Addendum No. 1

RE: Contract ID: C201954
WBS# 37651, etc.
Person County
NC-157 from the Orange County Line to
SR-1141 and 7 Sections of Secondary Roads

December 18, 2007 Letting

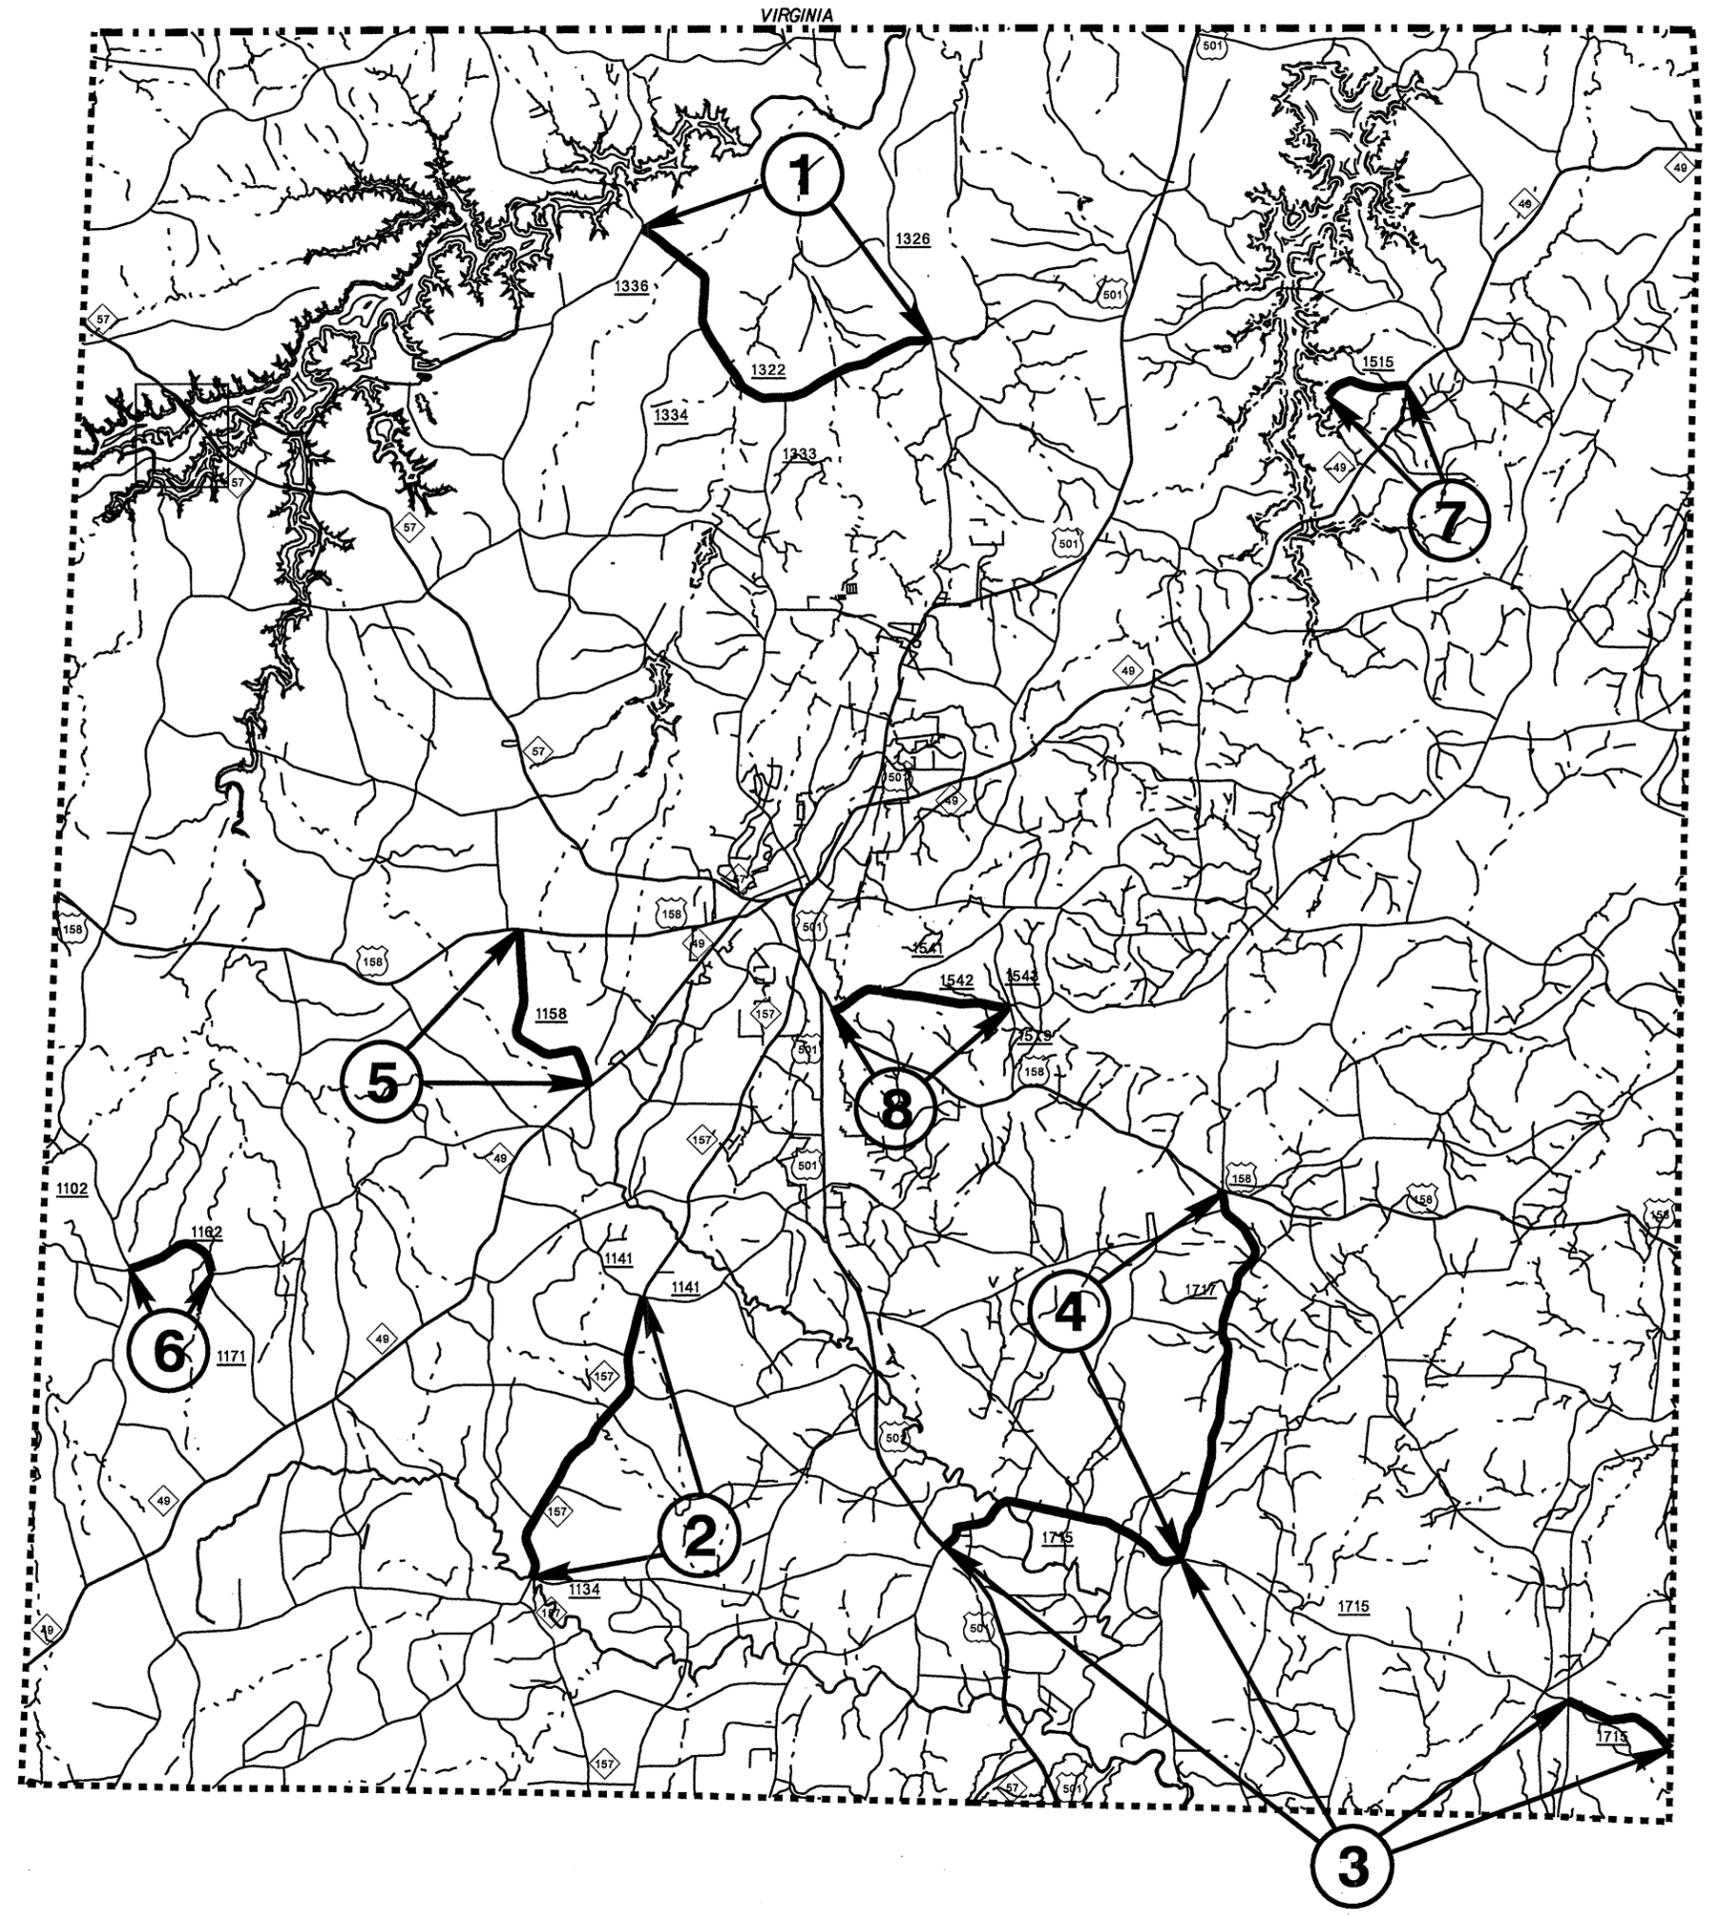
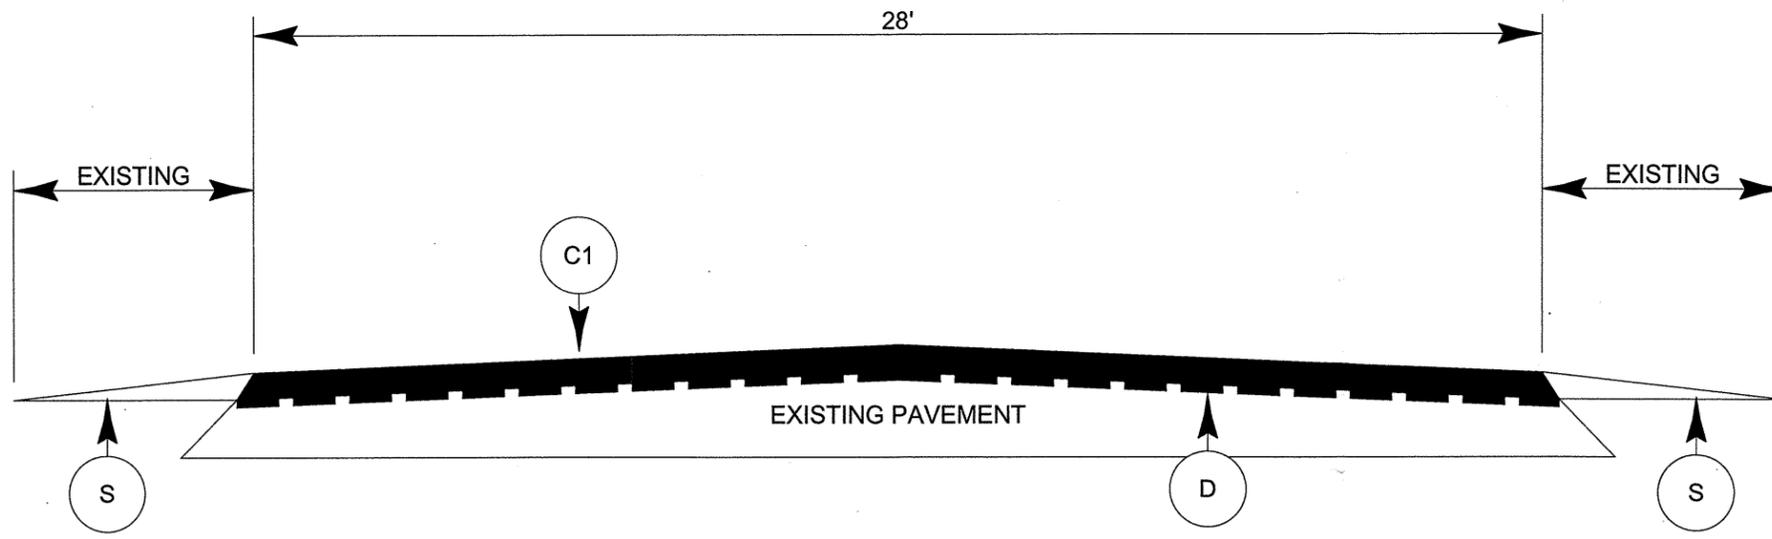
On Sheet No. 1 the limits for Map No. 2 and Map No. 3 have been revised. Please void Sheet No. 1 in your sketch maps and staple the revised Sheet No. 1 thereto.

PROJECT NO. 37651, 5CR.10731.6, 5CR.20731.6,	SHEET NO. 2	TOTAL SHEETS 4
--	-----------------------	--------------------------

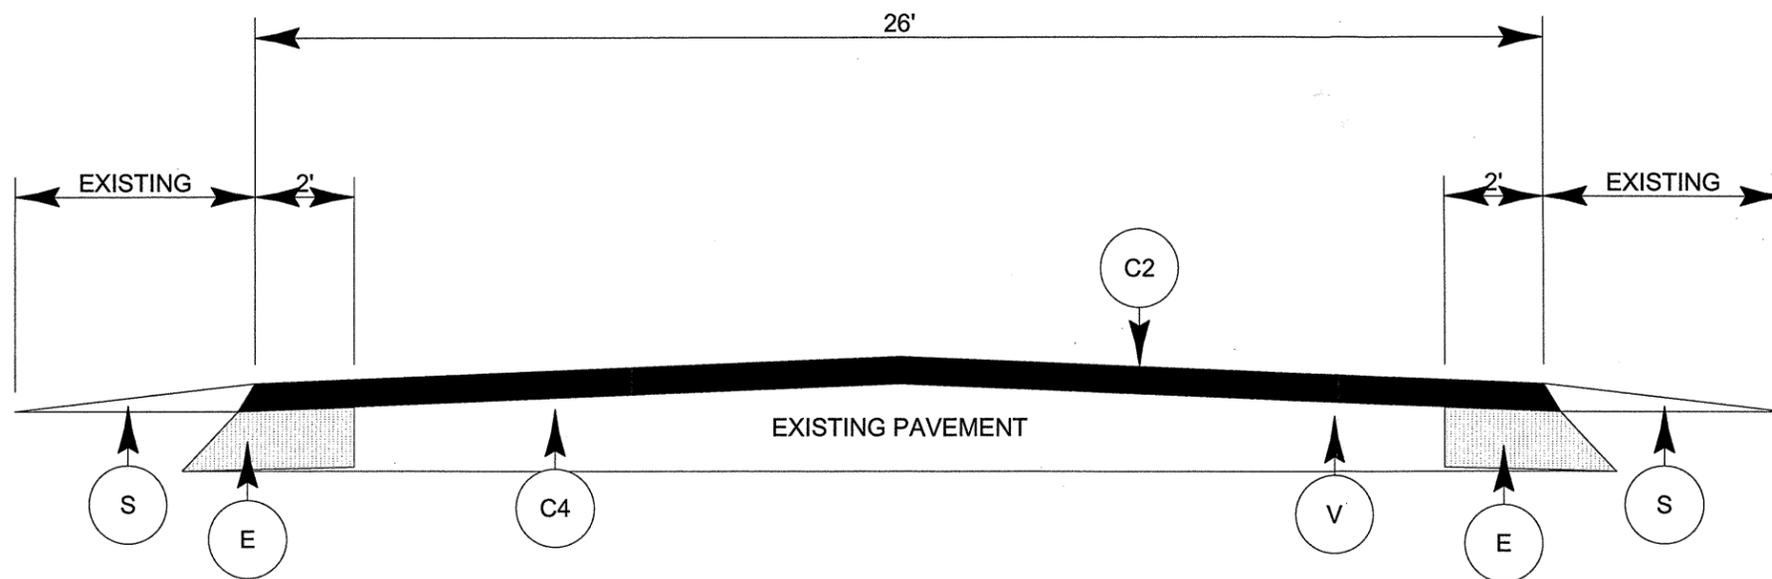
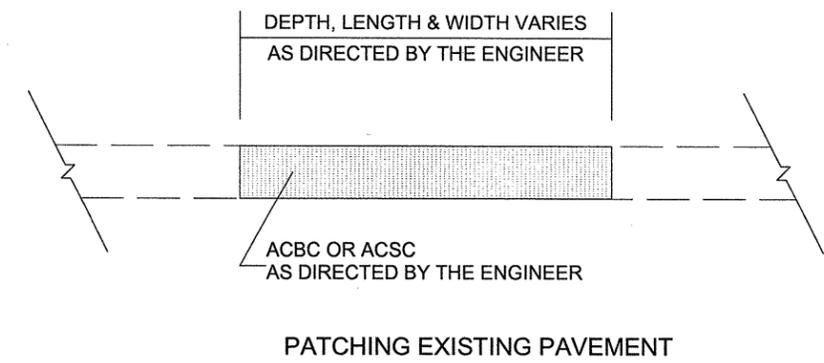
On Sheet No. 2, Typical Section No. 2 has been revised to add 2 ft. of widening to each shoulder. Please void Sheet No. 2 in your sketch maps and staple the revised Sheet No. 2 thereto.
